CITY OF PORTLAND, MAINE

September 18, 2018

Project Name: ScrubaDub Car Wash)
Address: 1185 Forest Avenue
Applicant: ScrubaDub Car Wash
Planner: Matthew Grooms

Project ID: PL-000113-2018,
CU-000120-2018
CBL: 152-B-002

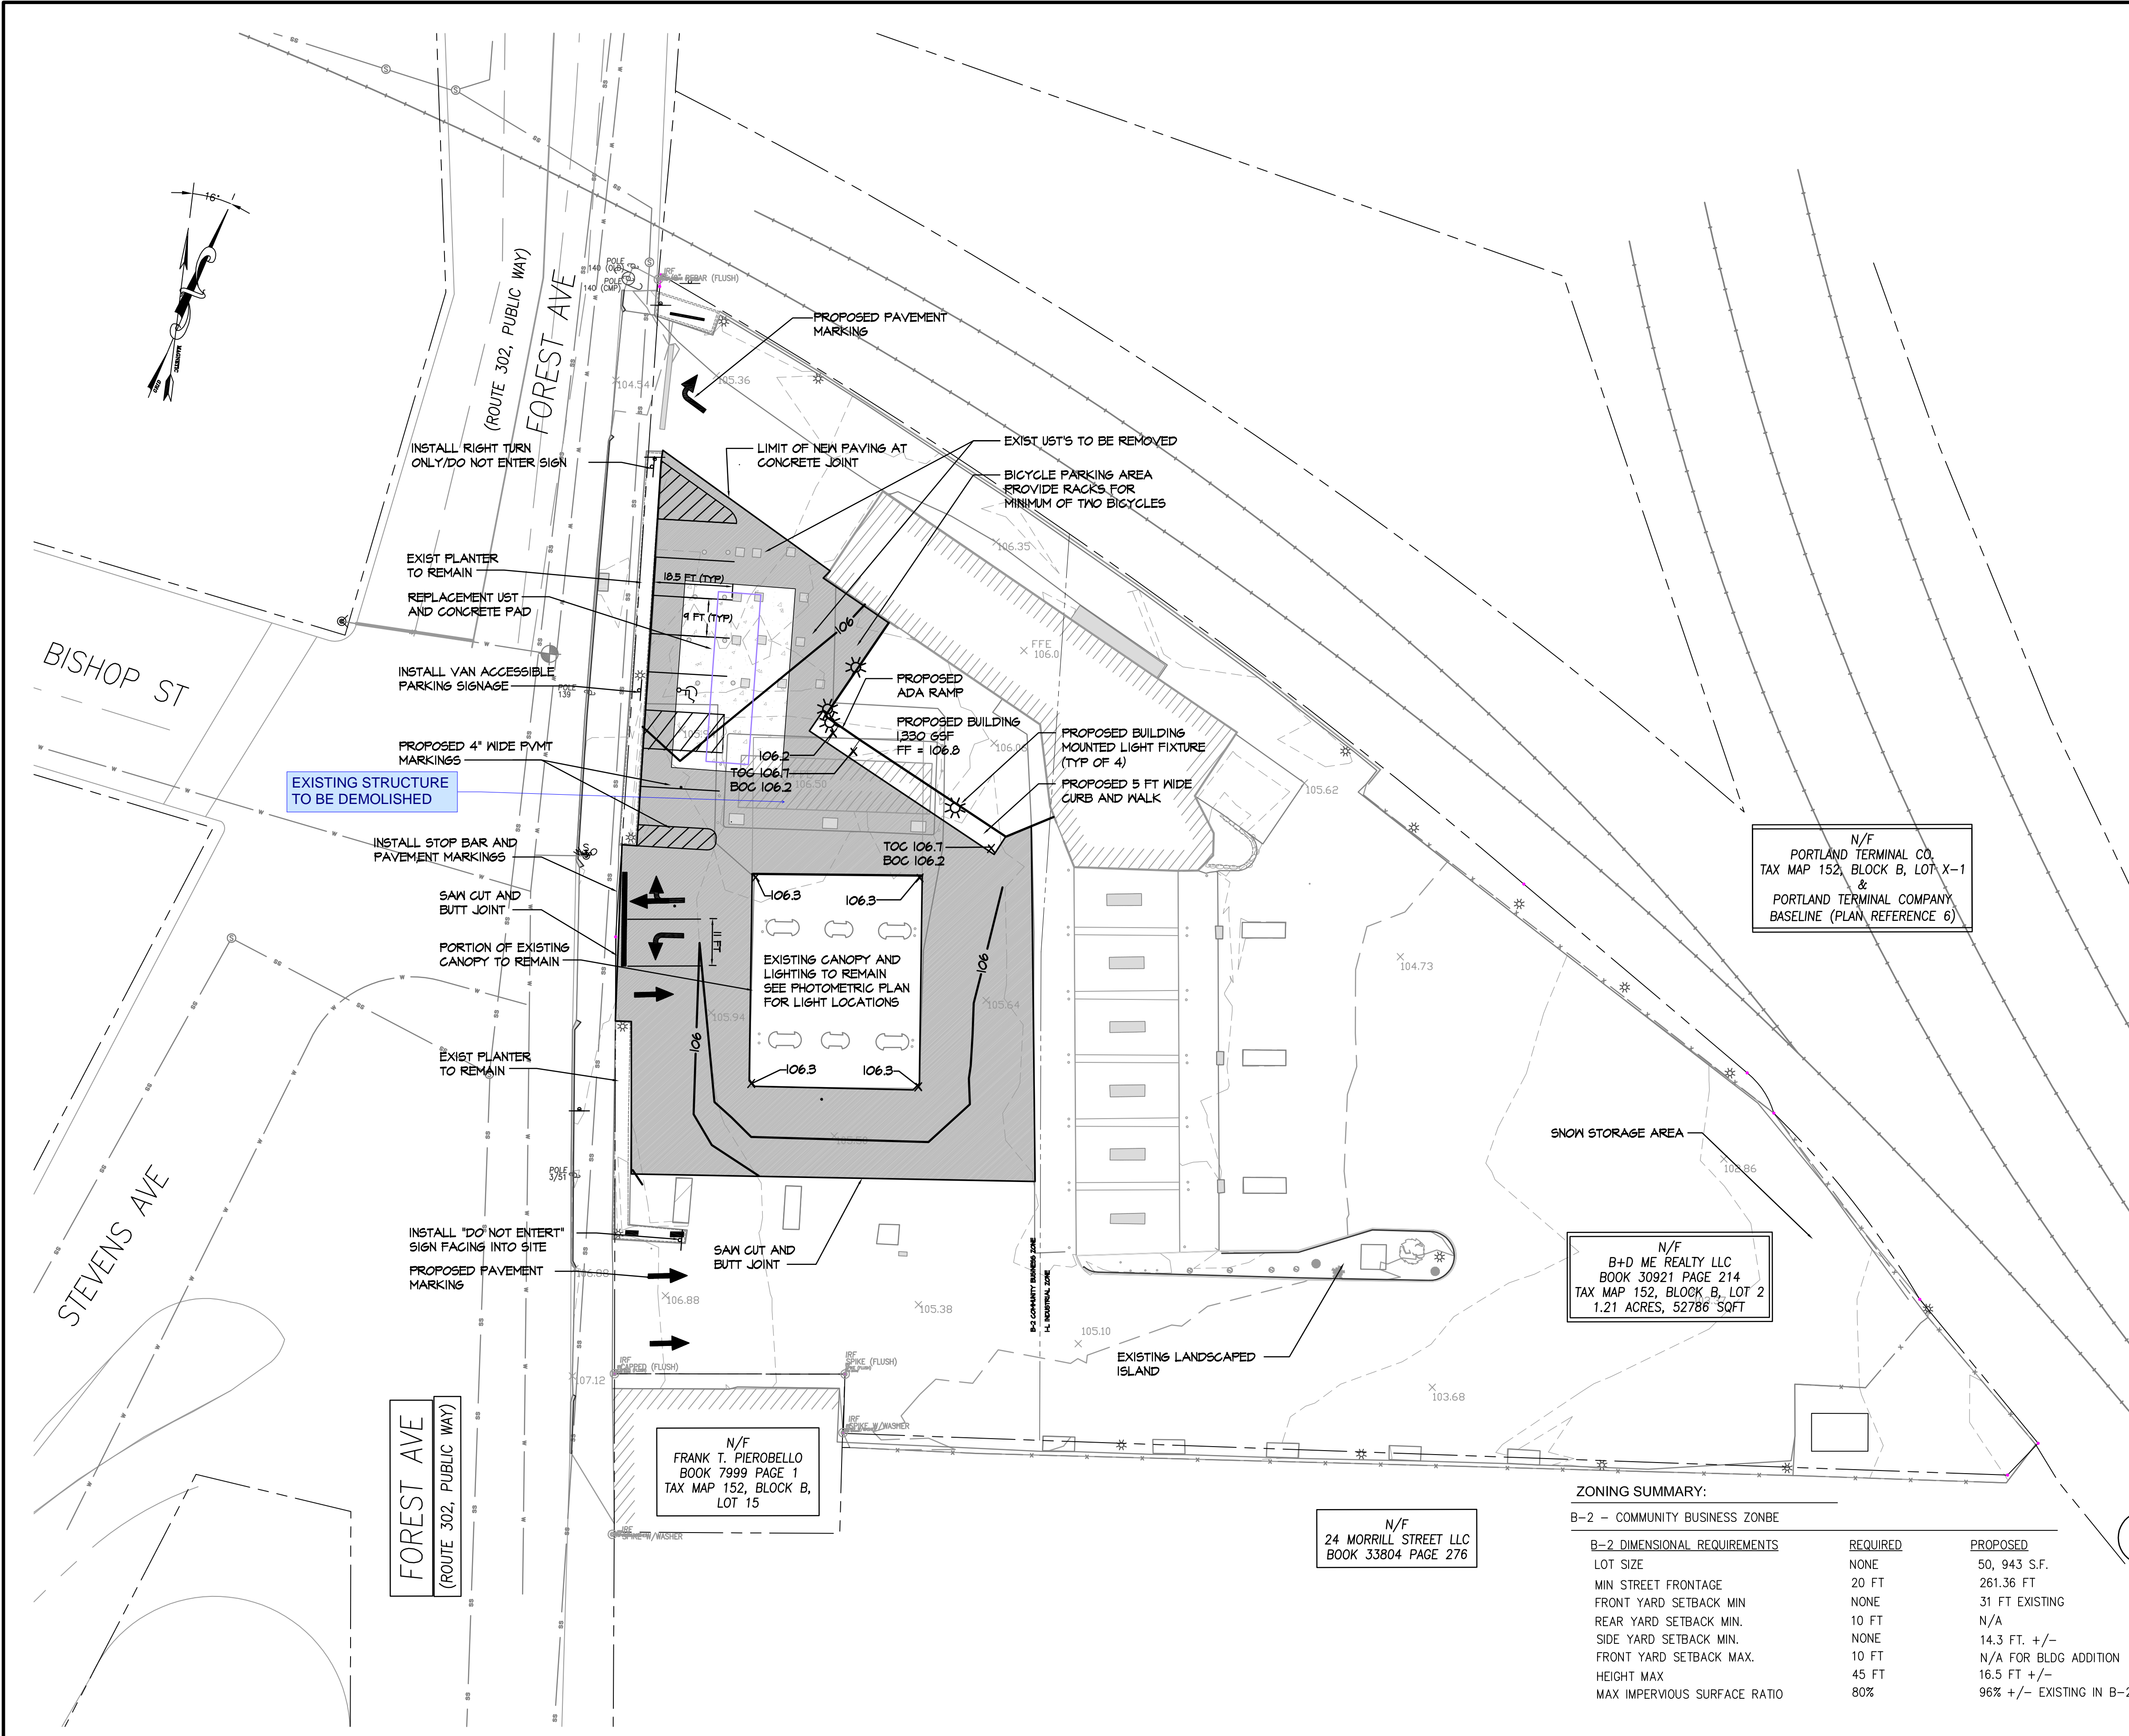
3. The applicant shall submit an updated site plan that addresses Tom Errico's comments dated September 7, 2018, which request the following improvements:

- a. An entry arrow shall be installed for the main middle driveway
 - b. A right-turn exit arrow shall be installed for the northerly driveway
 - c. An entry arrow shall be installed for the southerly driveway. A "Do Not Enter" sign shall be installed reinforcing the entry only condition.

4. Per Design Review comments dated August 27, 2018, the applicant shall submit an updated landscape plan to be reviewed and approved by the City Arborist and Urban Designer. The plan shall include a more substantial planter that provides an appropriate edge along the site and offers additional site buffering.
